RE: O'Keefe, Administrative Use Permit, AU-09-00002

Re: O'Keefe Accessory Dwelling Unit, AU-09-00002

TO: Jeff Watson
FROM: Christina Wollman, Planner II *CS*
DATE: April 20, 2009
SUBJECT: O'Keefe Accessory Dwelling Unit AU-09-00002

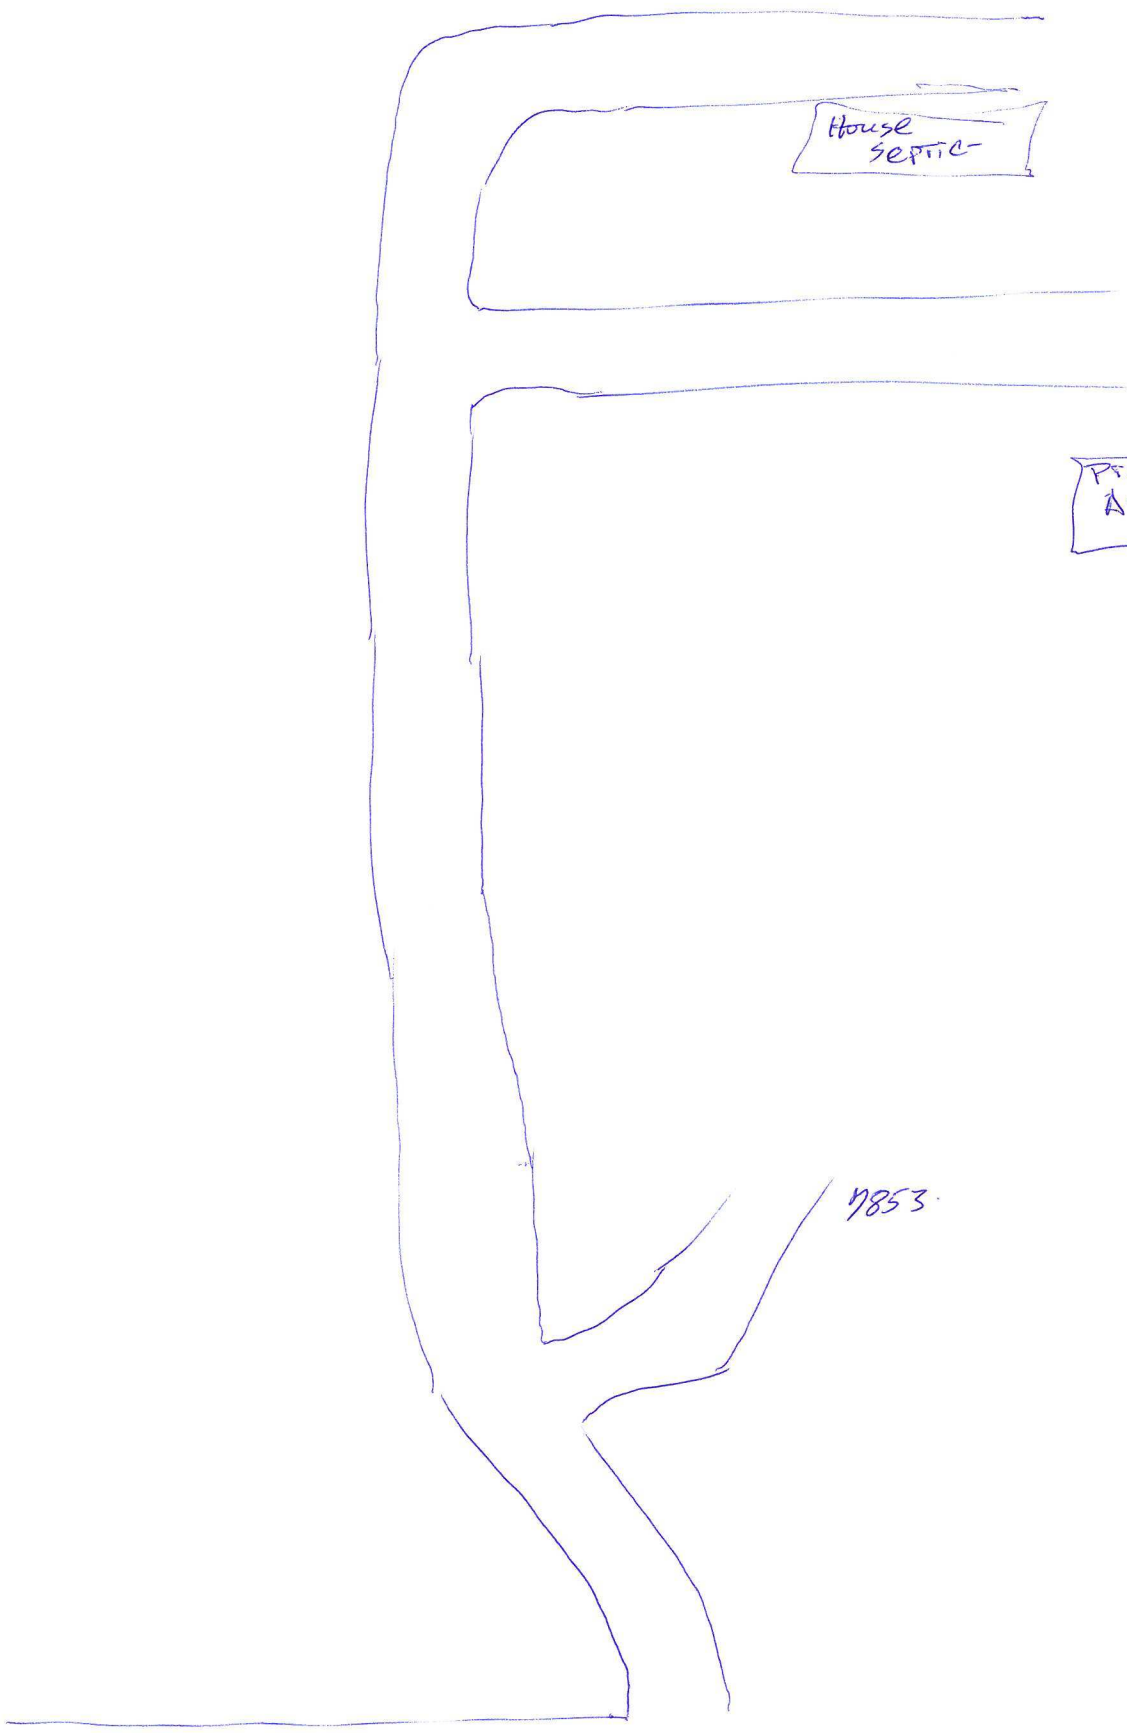
- A. Access: Access to the proposed new residence shall be from the existing driveway at 7851 Reecer Creek Road. The applicant must adhere to all regulations set forth in the Kittitas County Road Standards.
- B. Access Permit: An approved access permit will be required from the Department of Public Works prior to creating any new driveway access or performing work within the county road right of way.
- C. Addressing: Contact the Kittitas County Rural Addressing Coordinator at (509) 962-7523 to obtain addresses prior to obtaining a building permit. A parcel cannot receive a building permit or utilities until such parcel is identified with a 911 address.
